About the application

Application number: 2023/93387	
What is the application for?:	Erection of lower ground floor extension and first floor extension over bungalow
Address of the site or building:	Avondale, Wood Lane, Holmfirth, HD9 3JB
Postcode:	HD9 3JB

south west elevation (taken up Wood Lane)

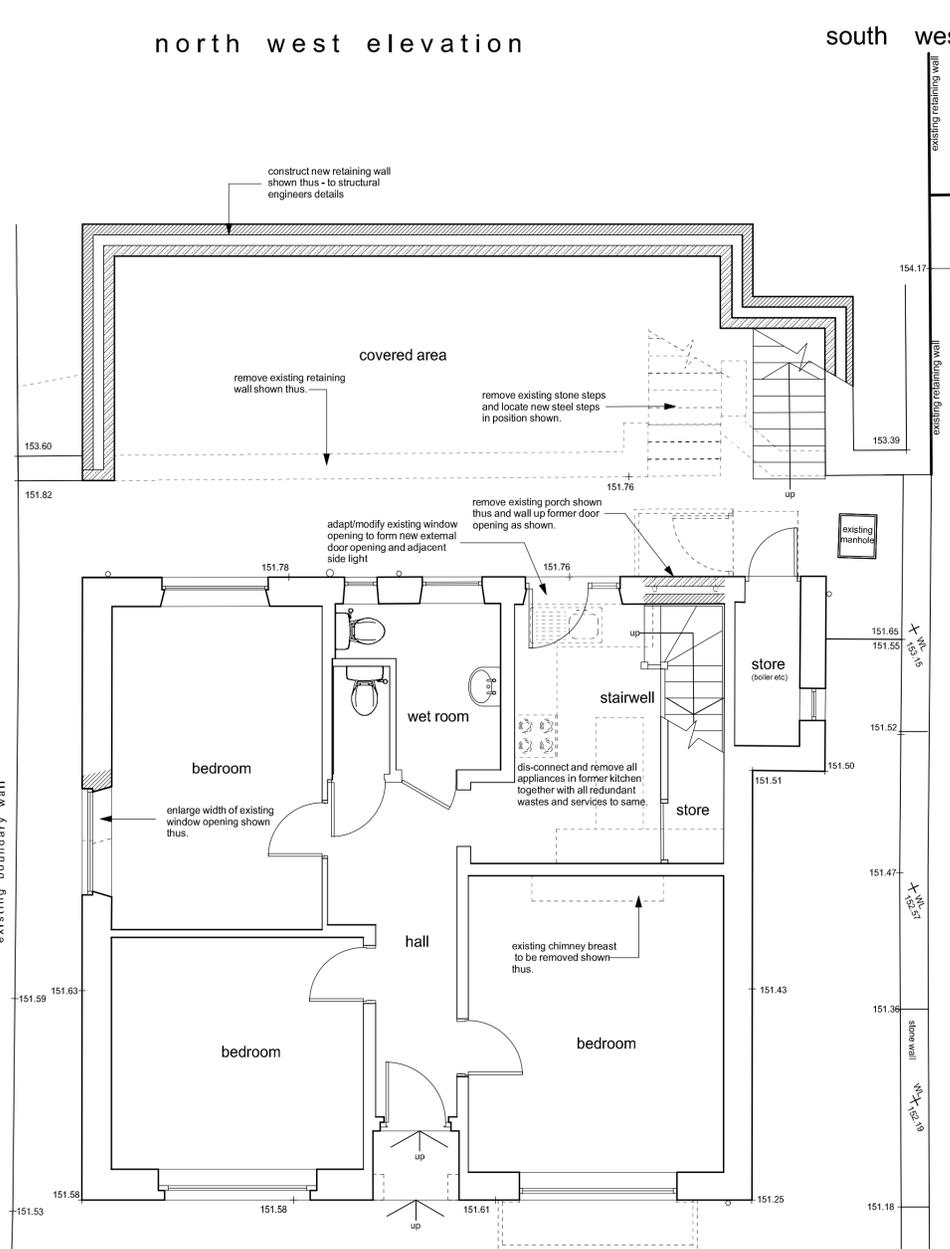
Type of comment: A general comment	
Do you wish your comments to be published on the website anonymously?	Yes
<p>My initial reaction from an inspection of the drawings including the side elevation from Wood Lane is the significant size and scale of the proposed development compared to the existing bungalow which has stood on this site for many years. Although the application describes the development as 'extensions' the bungalow will be converted to a house and the overall visual impact of the new building will be significant and incompatible with the present street scene.</p> <p>DESIGN - Is the proposed dwelling in keeping with the established character and appearance of dwellings within the street scene and wider locality. The front balcony design does seem out of keeping. Does the dwelling secure a high quality design as required by the National Planning Policy Framework (NPPF) and would further be contrary to Policy LP24 of the Kirklees Local Plan.</p> <p>HERITAGE - The dwelling sits on the boundary with the Conservation Area. Due to the size, scale, form and detailed design, the dwelling would fail to preserve or enhance the significance and setting of the asset, contrary to the NPPF and Policy LP35 of the Kirklees Local Plan.</p> <p>ACCESS / PARKING - No tracking plans or similar have been provided to demonstrate that vehicles can appropriately manoeuvre from the parking area. The adjacent lane is narrow and steep with a footpath and degrading road surface. The plans are also unclear in terms of the removal of the wall to facilitate the parking area (the loss of the wall is regrettable as it positively contributes to the character of the lane, which forms the edge of the sensitive Conservation Area boundary).</p>
